Re: 2300 Central Building Renovation, 2300 Central Ave. SE, Traffic Circulation

Layout

Architect's Stamp dated 3-30-04 (K16/D41)

Re: 2300 Central Building Renovation, 2300 Central Ave. SE, Traffic Circulation Layout

TCL SITE PLAN
1" = 20'-0"

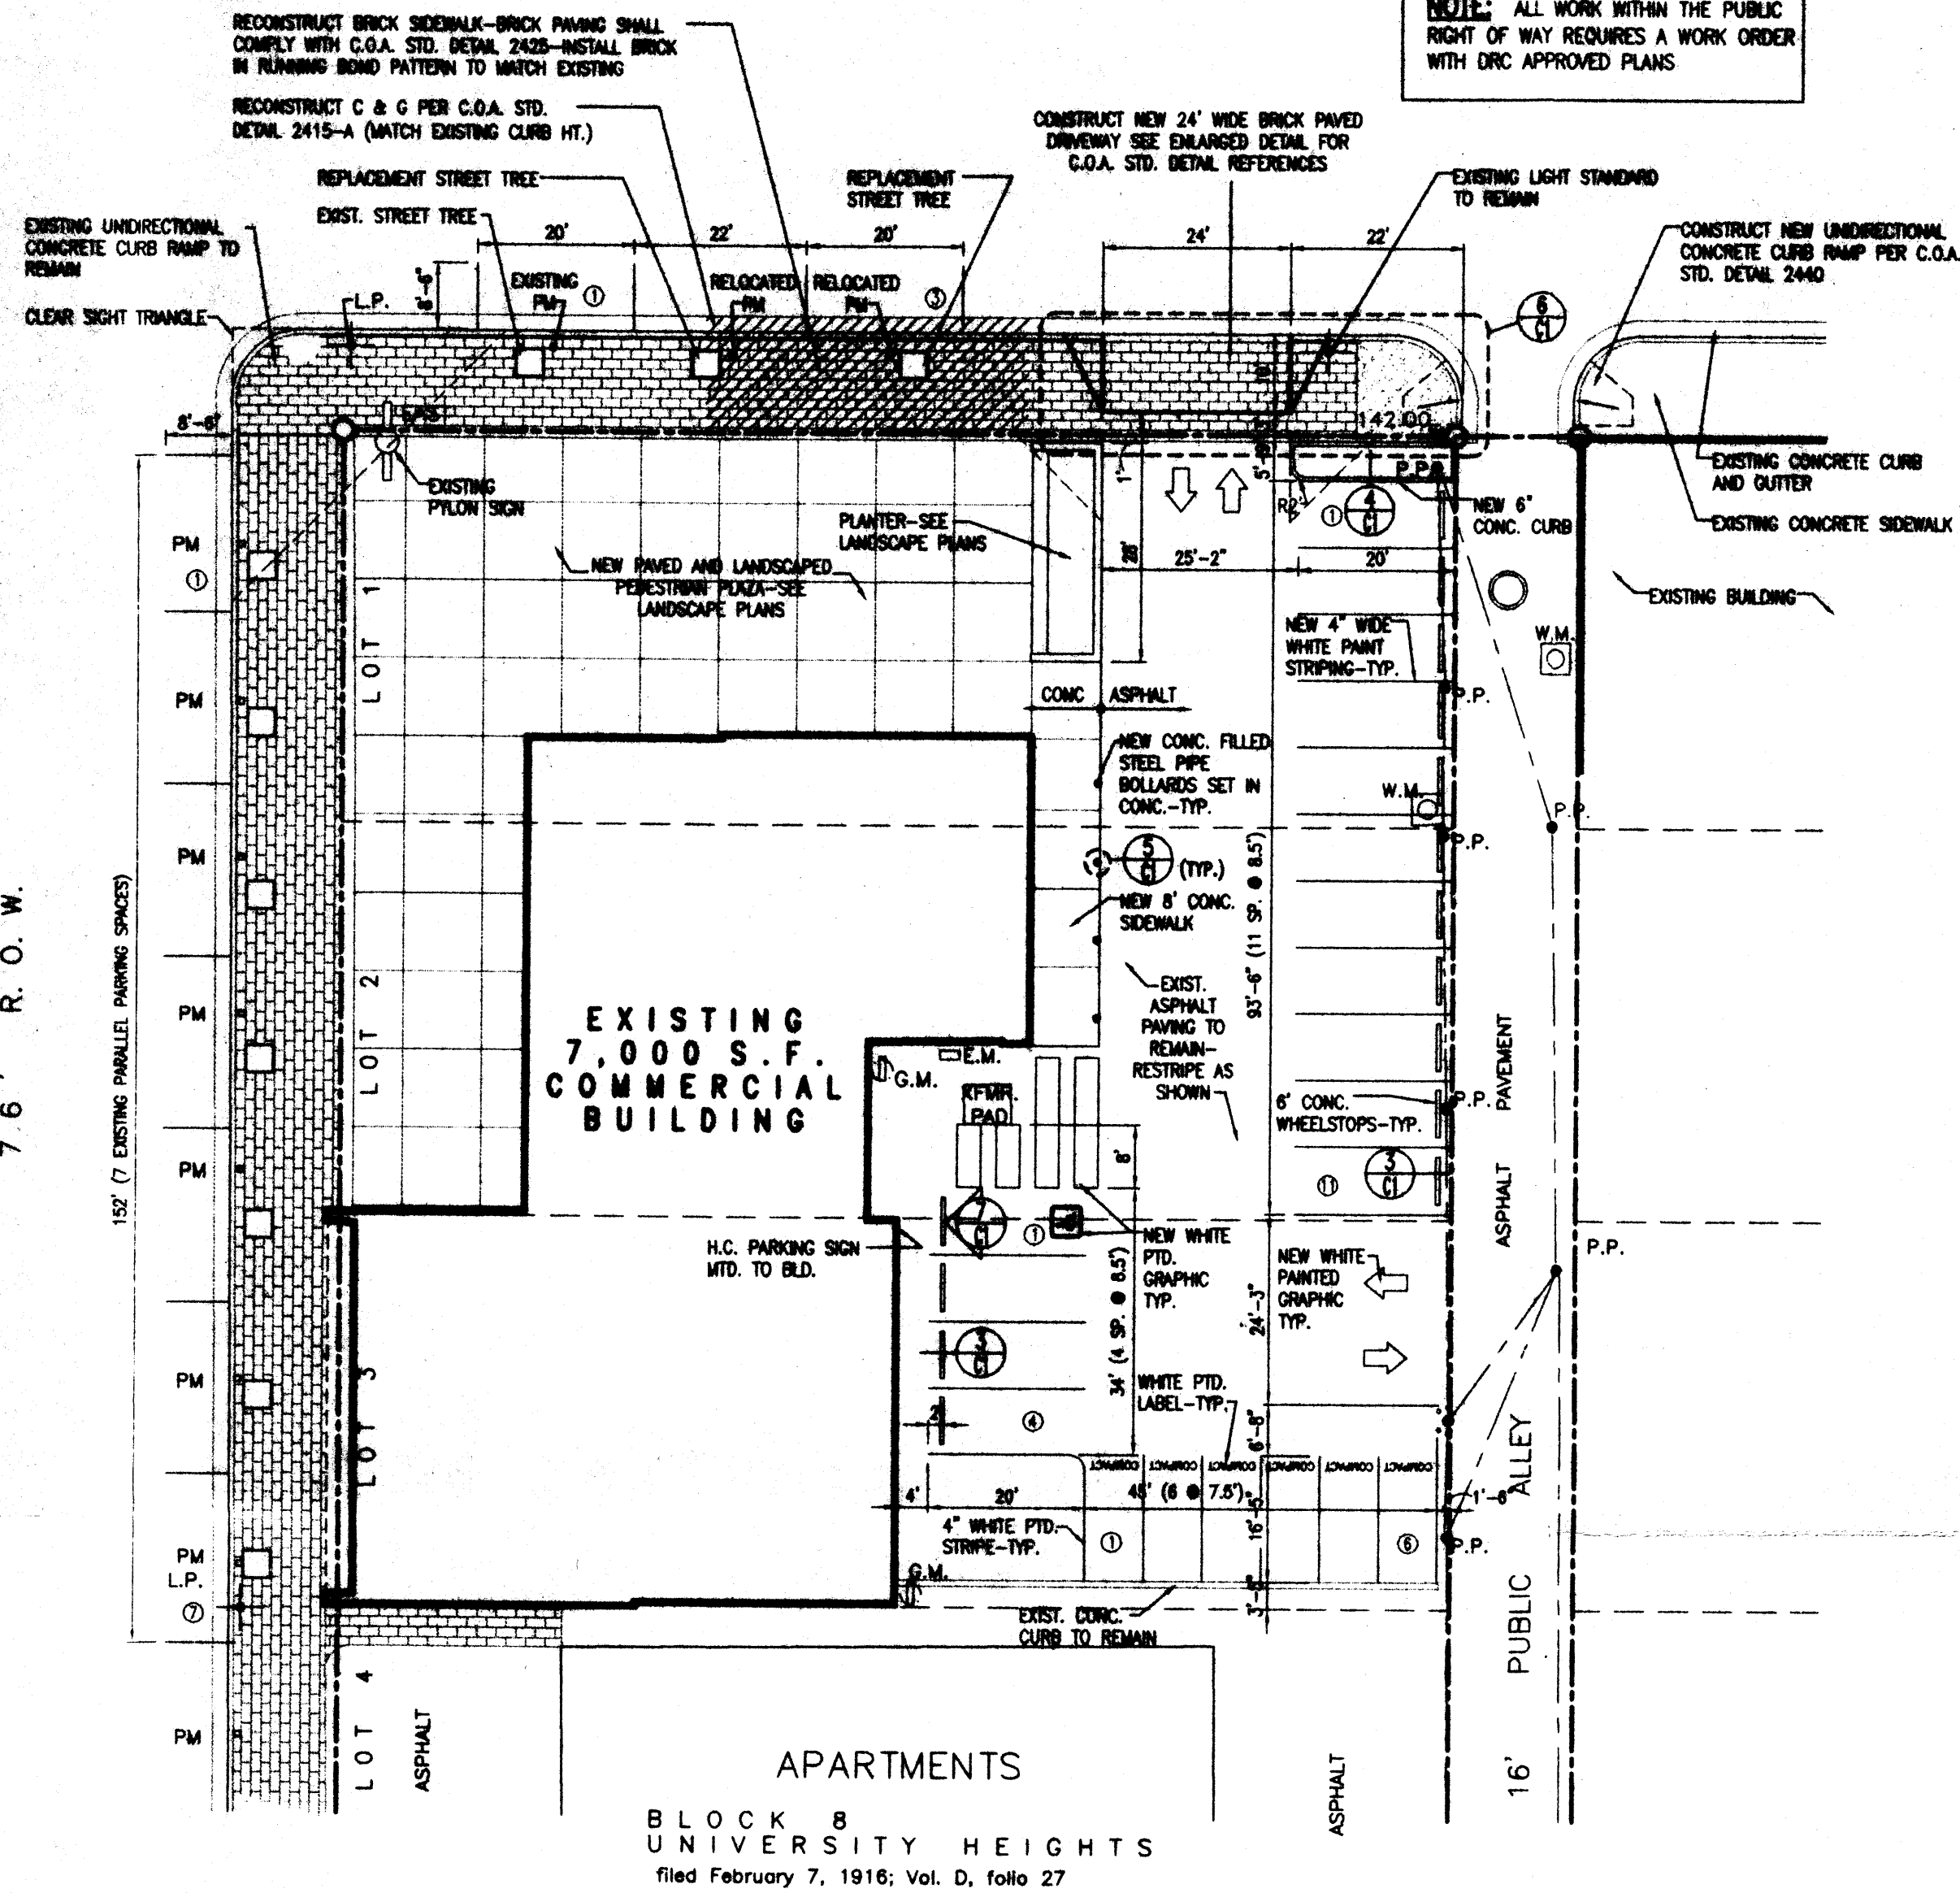
• The number of parking spaces required by the zoning code is greater than the proposed number of parking spaces. If zoning has allowed this project to have fewer than the required number of spaces, please include a copy of this waiver.

- 1. List the number of parking spaces required by the zoning code as well as the proposed number of parking spaces. If zoning has allowed this project to have fewer than the required number of spaces, please include a copy of this waiver.
- 2. Please list the width for all parking spaces.
- 3. Show a detail of the proposed driveway to demonstrate its ADA compliance.
- 4. Define width of the proposed sidewalk.
- 5. What is the distance from the edge of the ramp to the edge of the sidewalk?
- 6. Work within the public right of way requires a work order with DRC approved plans.
- 7. List the width of the handicapped spaces (minimum of 8.5 feet in width).
- 8. Please call out which City Standards are to be used.
